Memorandum

Project: Wisenteiner Residence

We received the permit comments from Mercer Island for the Wisenteiner Residence project. This letter serves as our response to the comments:

WISENTEINER RESIDENCE
PROJECT

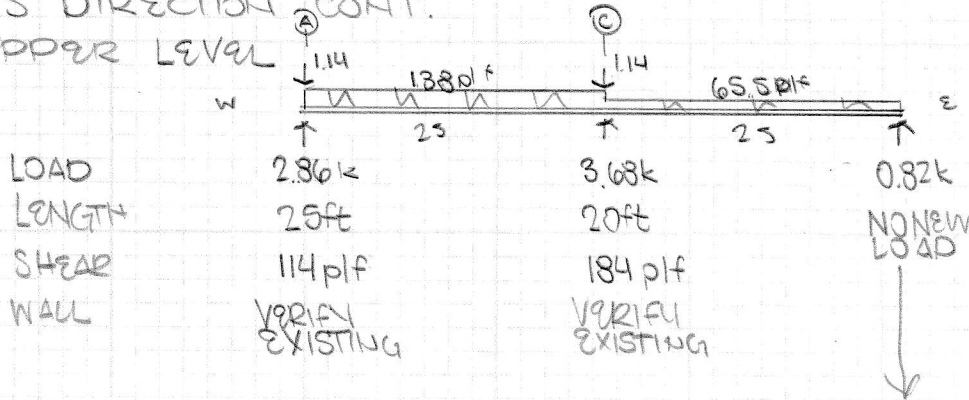
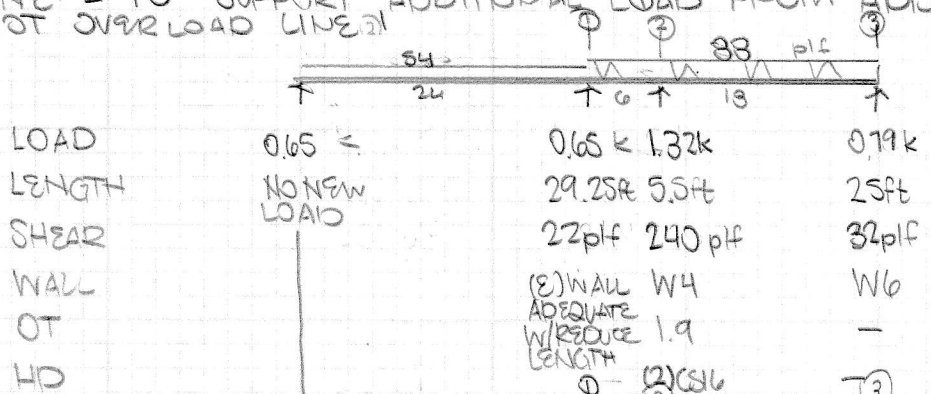
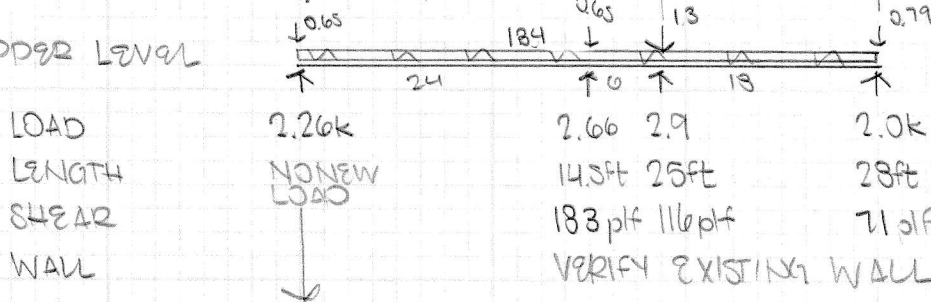
Page	Comment
9	<i>Provide shearwall schedule</i> Shear Wall schedule has been provided
9	<i>Provide interconnectedness</i> Detail has been added to show the connection of the existing structure to the new structure.
9	<i>It appears that the intent may be to cantilever the floor and roof lateral load back into the garage shearwall line. Please justify. Any attachment of the existing structure would appear to increase the lateral load to the house shearwall line. Please address</i>

9	<p><i>Provide details as necessary to fully describe construction.</i></p> <p>Additional details have been provided.</p>
9	<p><i>Callout all details.</i></p> <p>Details have been called out on plan.</p>
9	<p><i>Provide lateral design. This area is mapped with a wind speed up value of 1.6</i></p> <p>Lateral design has been provided. Per calculations on criteria sheets 4-6 Kzt was calculated to be 1.42</p>
9	<p><i>Roof Framing Plan?</i></p> <p>Plans have been revised to indicate as roof framing plans.</p>
10	<p><i>Revise detail to show accurate location of continuous rim joist.</i></p> <p>Detail is already coordinated with architectural drawings.</p>
10	<p><i>Provide calculations to justify design.</i></p> <p>Calculations have been provided on L4</p>
10	<p><i>What is the minimum dept of sheathing? Does the sheathing run full length?</i></p>

<p>In order to not overload the existing walls along grid 1 as indicated in lateral calculations, a new shear wall was added in the addition to support the lateral loads at the roof for the new addition. This force is then dragged into the north garage wall below. Minimum existing condition requirements are listed on plan, as well as upgrade requirements if the wall does not minimum requirements.</p>
9	<p><i>Provide interconnectedness, chord continuity and reentrant corner reinforcing, typical.</i></p> <p>Additional details have been added to show the connection of the addition to the existing structure.</p>
9	<p><i>Indicate as new wall</i></p> <p>Wall has been indicated as a new wall</p>
9	<p>New header required? Confirm adequate existing lateral capacity. Address removal of existing wall as well as tributary of new addition.</p> <p>Location is non-load bearing, no new header required. Additional lateral load from addition is supported along Grid 2 and not Grid 1 as outlined in the lateral calculations so as to not overload the existing walls. Existing walls along grid 1 were examined with reduced wall length and were found to still be adequate.</p>
